CITY OF ALBUQUERQUE

July 29, 2019

Re: Maverik University & Menaul
1901 Menaul Blvd NE Albuquerque Nm 87107
Traffic Circulation Layout
Engineer's/Architect's Stamp 07-25-2019 (H15D068)

Based upon the information provided in your submittal received 07-25-2019, the above referenced plan cannot be approved for Building Permit until the following comments are addressed:

MAVERIK UNIVERSITY & MENAUL TRAFFIC CIRCULATION LAYOUT	DRAWN BY FB DATE 11/18/2019 2018052-TCL
	TIERRA WEST, LLC 5571 MIDWAY PARK PLACE NE ALBUQUERQUE, NM 87109 (505) 858-3100 www.tierrawestllc.com	SHEET # TCL-1 JOB # 2018062

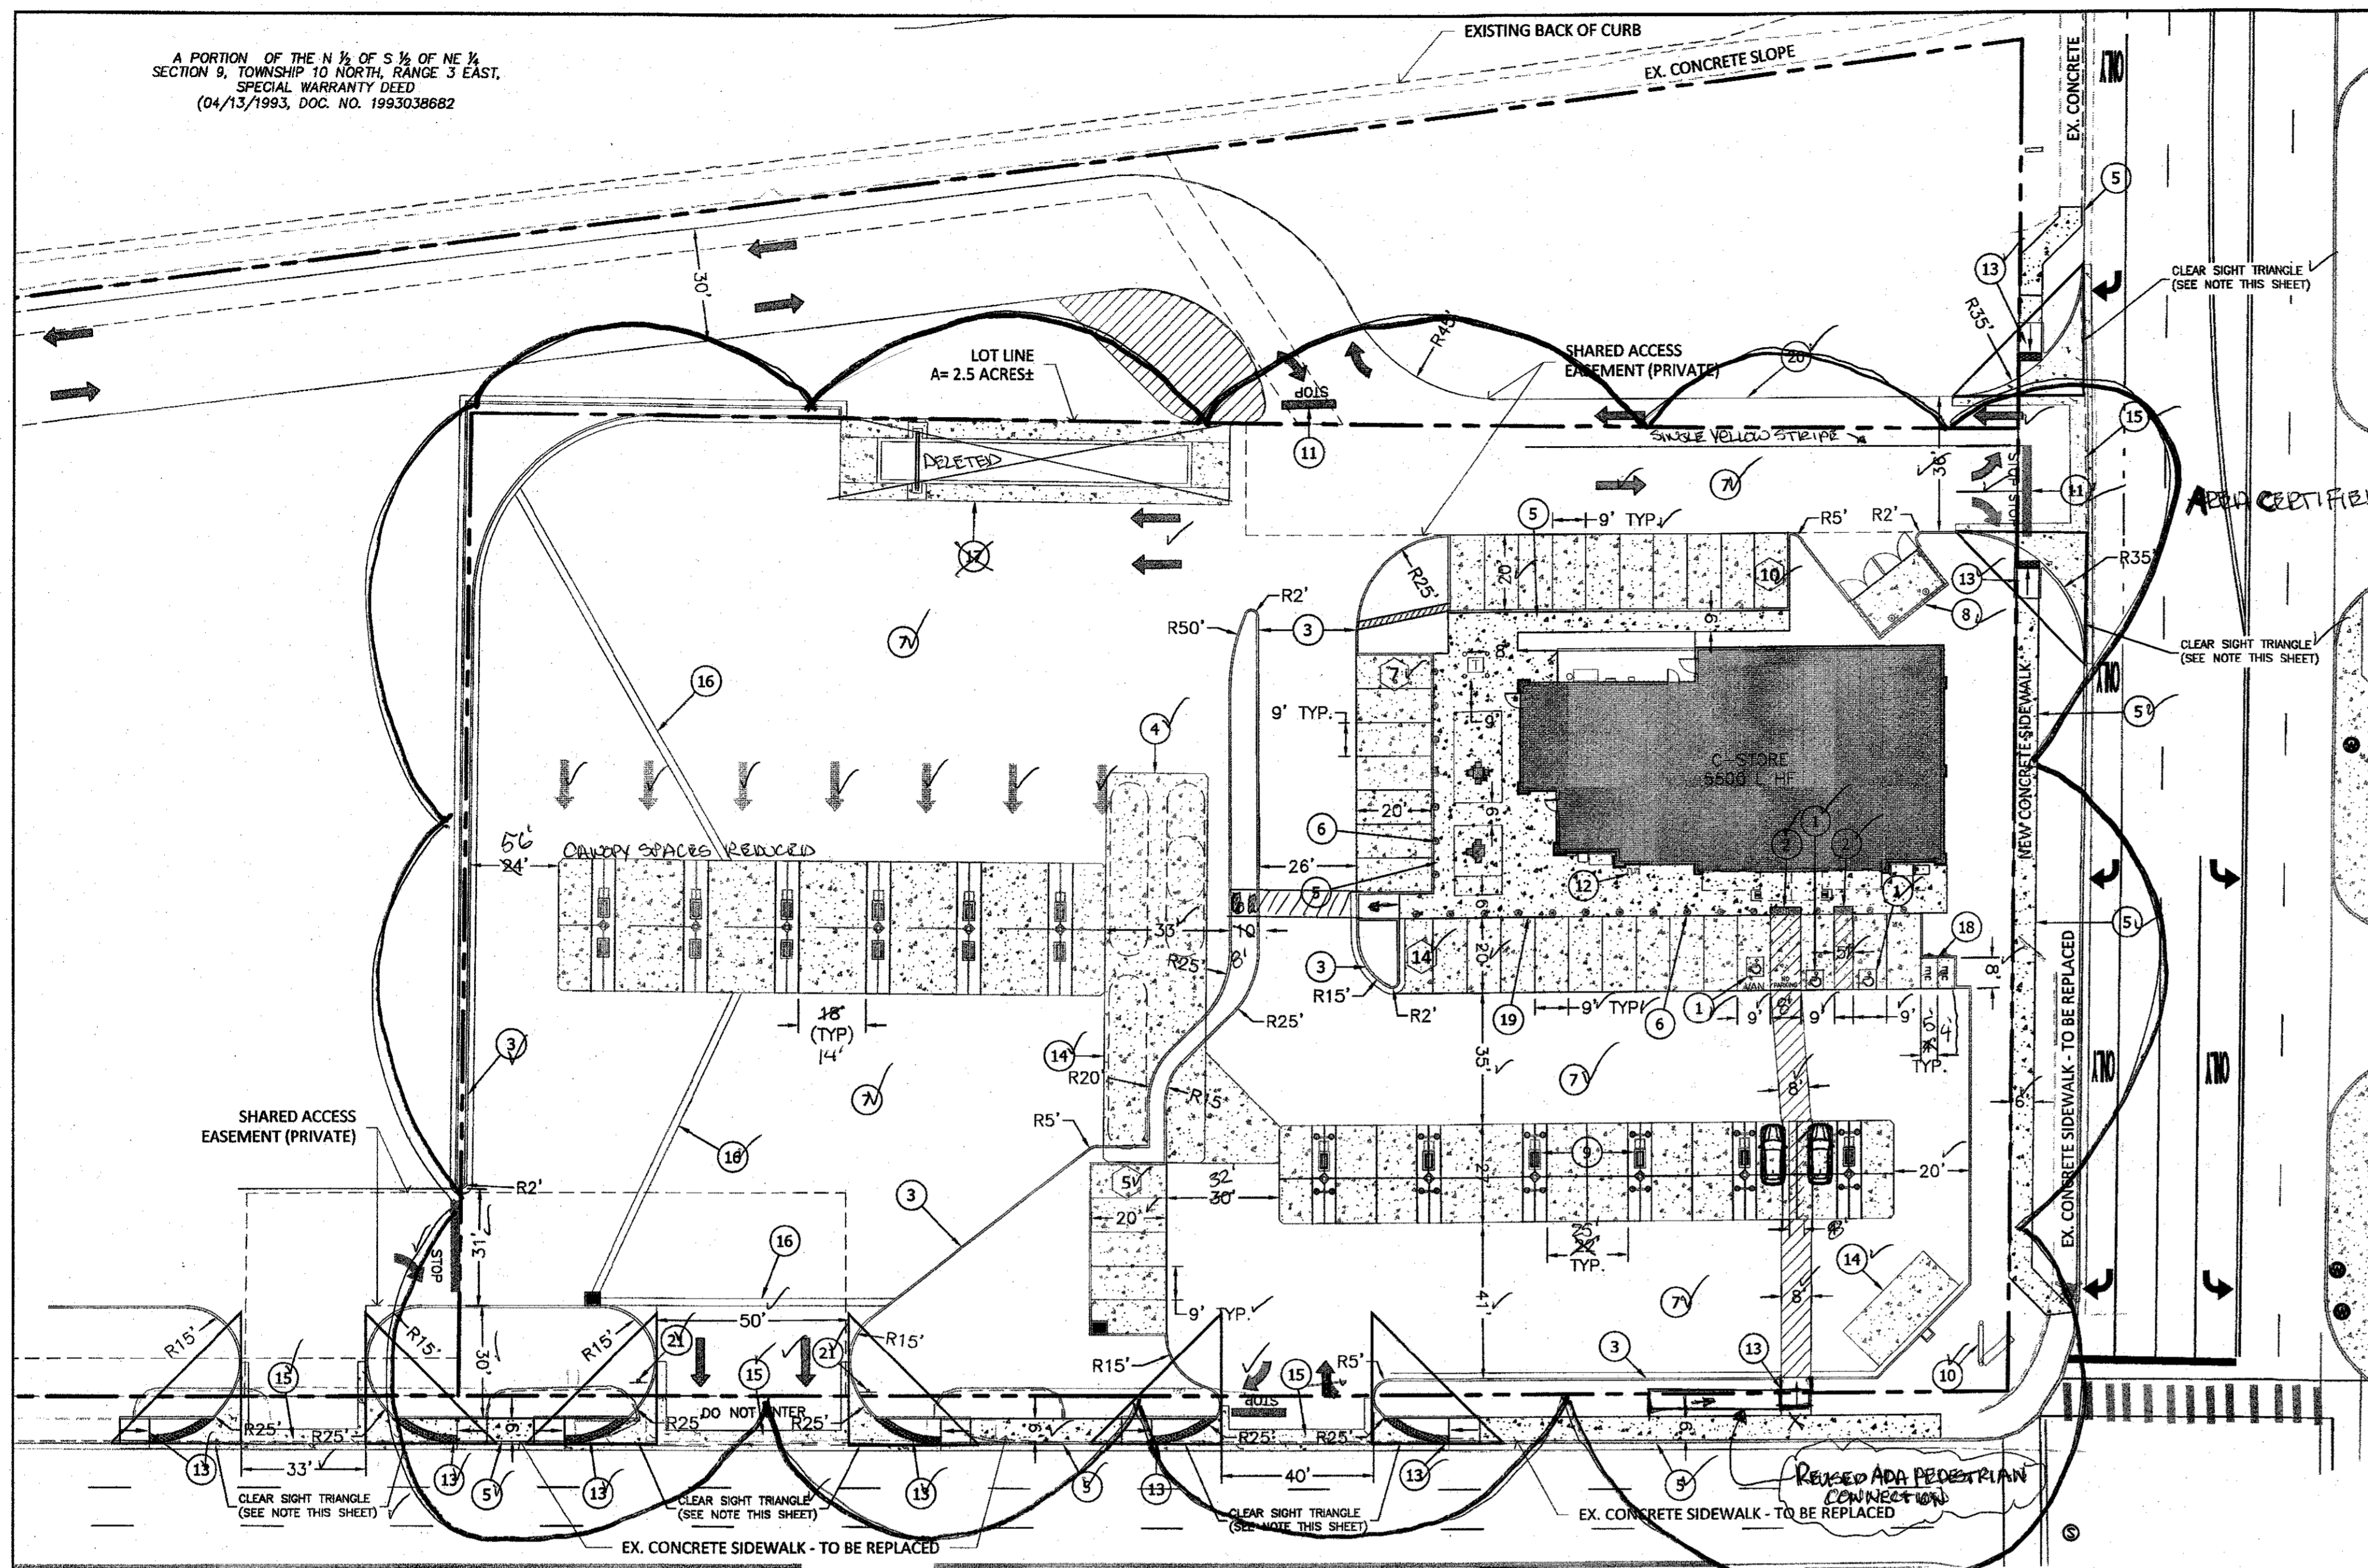
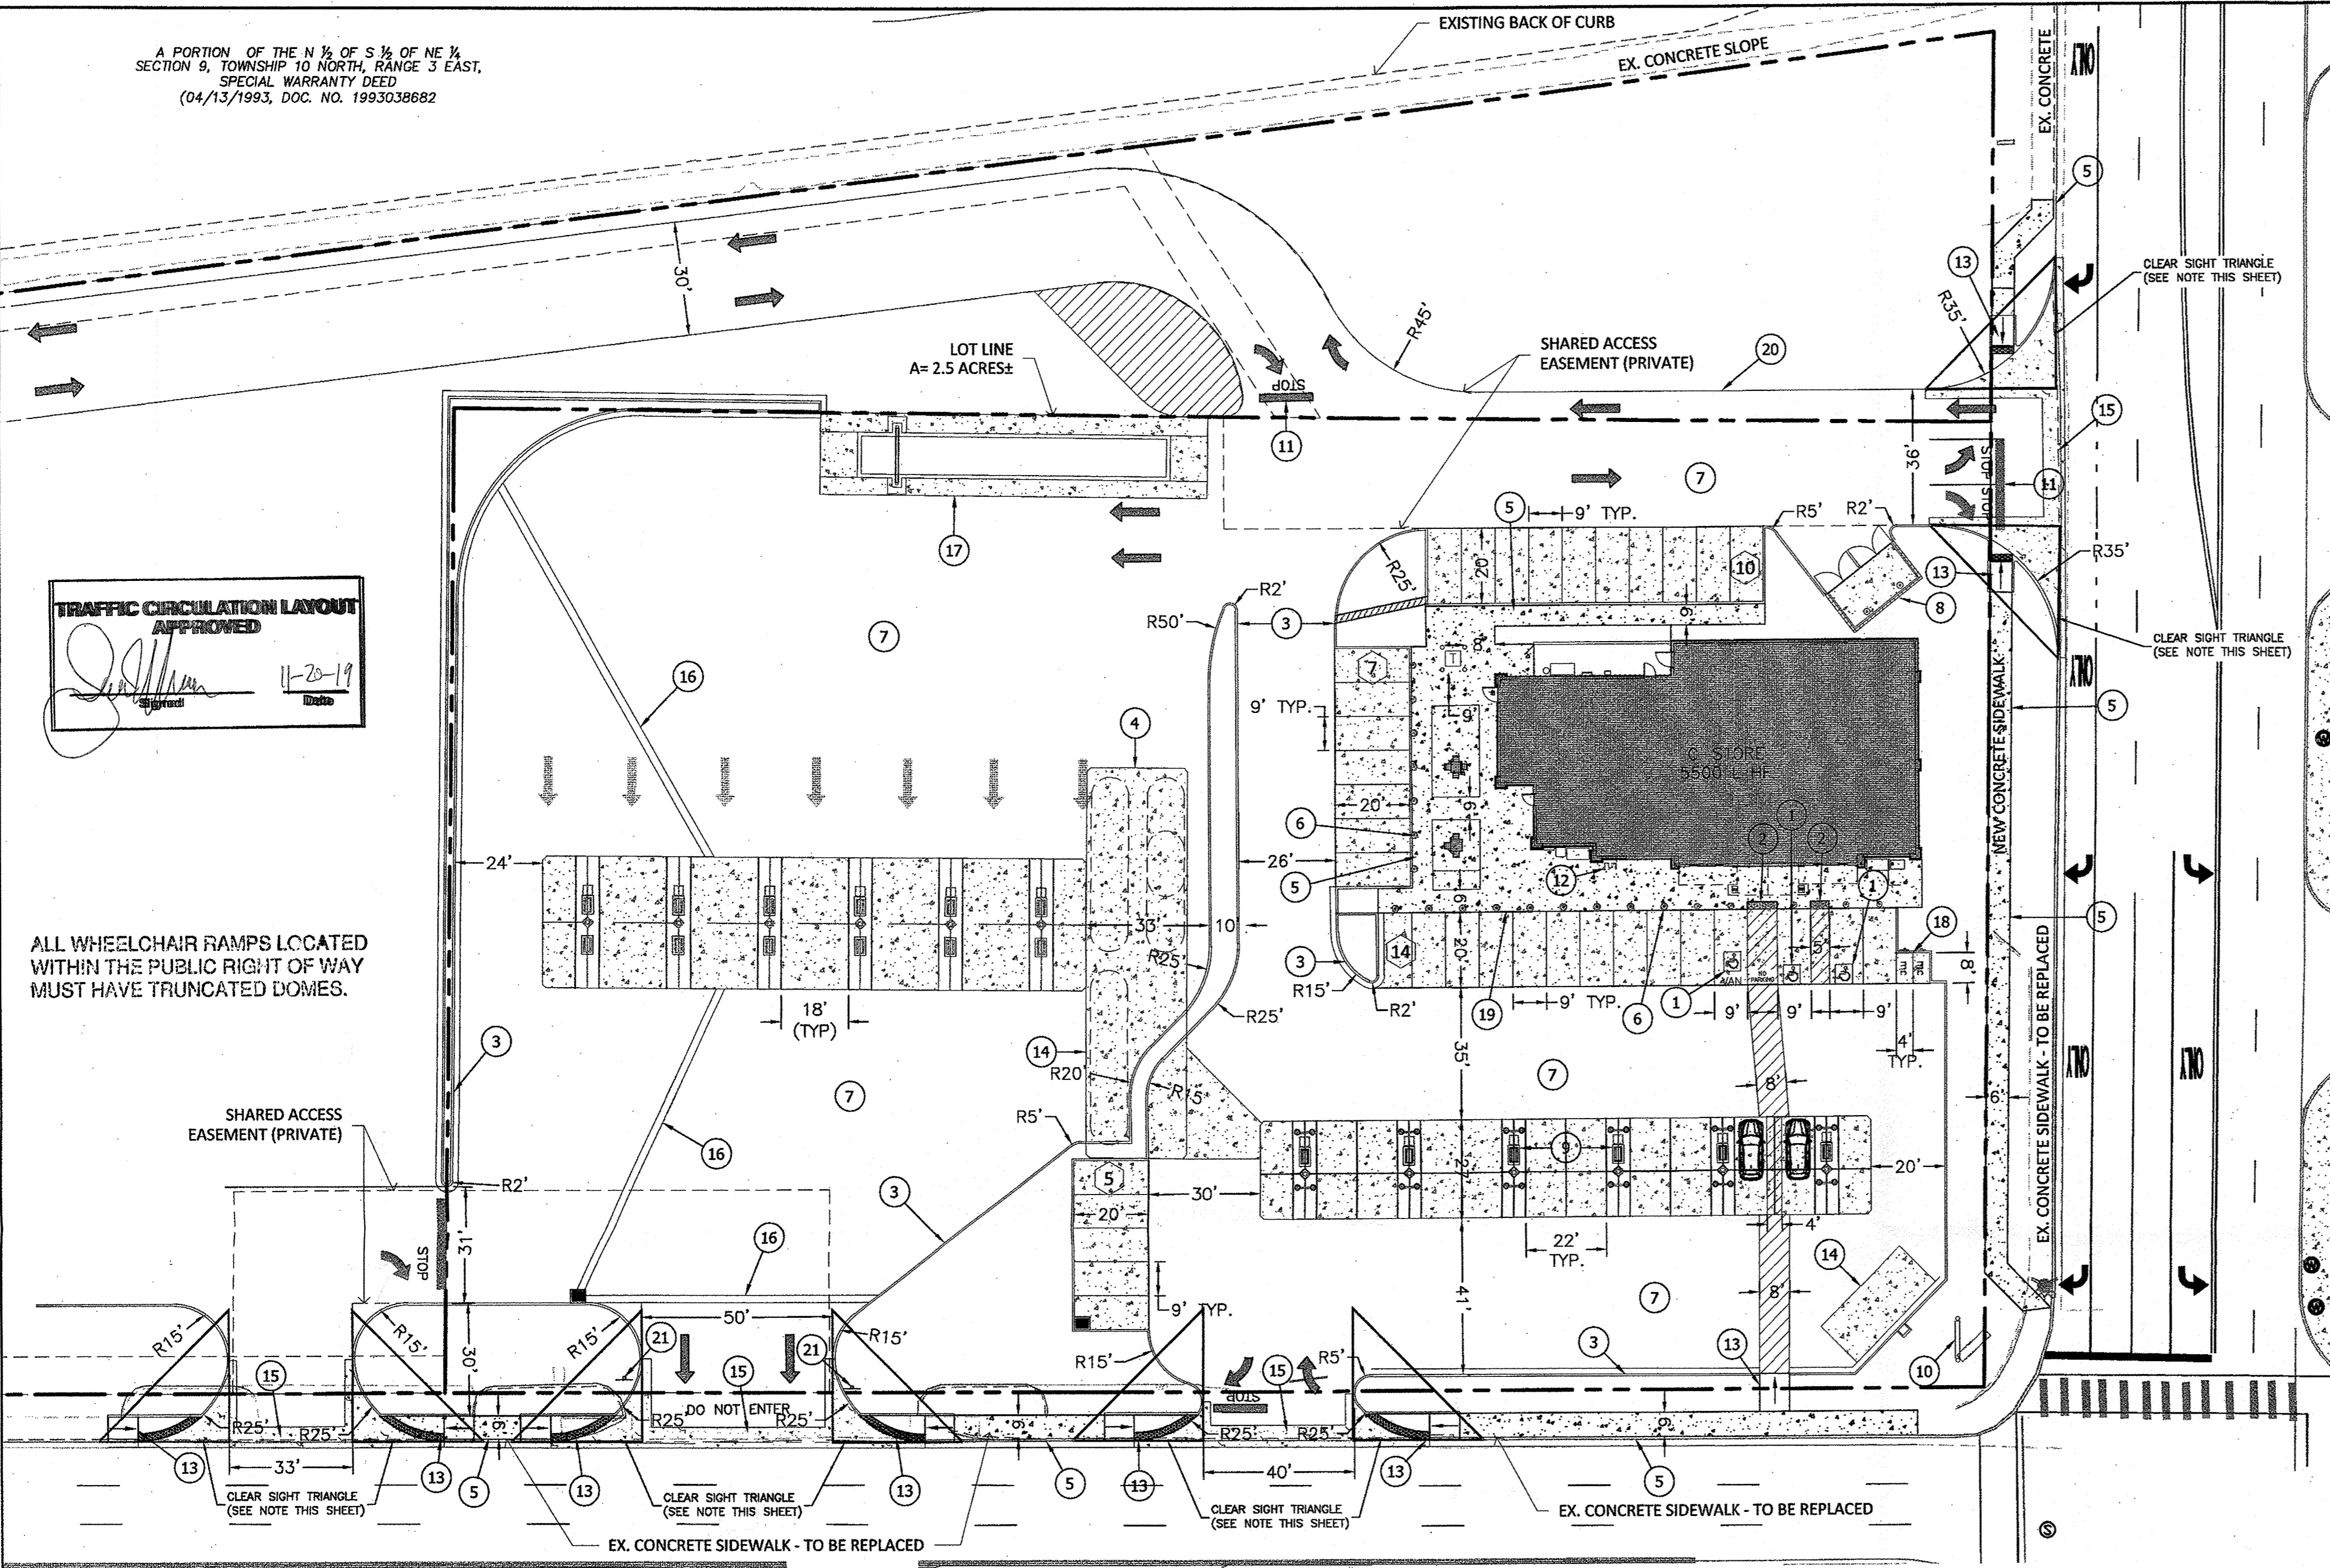
1. All bicycle racks shall be designed according to the following guidelines:
 - a. The rack shall be a minimum 30 inches tall and 18 inches wide.
 - b. The bicycle frame shall be supported horizontally at two or more places. Comb/toaster racks are not allowed.

- c. The rack shall be designed to support the bicycle in an upright position. See the IDO for additional information.
 - d. The rack allows varying bicycle frame sizes and styles to be attached.

- e. The user is not required to lift the bicycle onto the bicycle rack.
 - f. Each bicycle parking space is accessible without moving another bicycle.

2. Bicycle racks shall be sturdy and anchored to a concrete pad.
3. A 1-foot clear zone around the bicycle parking stall shall be provided.
4. Bicycle parking spaces shall be at least 6 feet long and 2 feet wide.

5. Parking areas shall have barriers to prevent vehicles from extending over public sidewalk, public right-of-way, or abutting lots.
6. provide a copy of refuse approval.

7. All one-way drives shall have "One Way" and "Do Not Enter" signage and pavement markings. Please show detail and location of posted signs and striping.

8. Please provide a sight distance exhibit
9. Work within the public right of way requires a work order with DRC approved plans.

10. Please add a note on the plan stating "All improvements located in the Right of Way must be included on the work order."
11. Add a note stating "All broken or cracked sidewalk must be replaced with sidewalk and curb & gutter." A build note must be provided referring to the appropriate City Standard drawing.
12. A replat needs to be approved before before the TCL approval.
13. Approved TIS is needed before TCL approval.
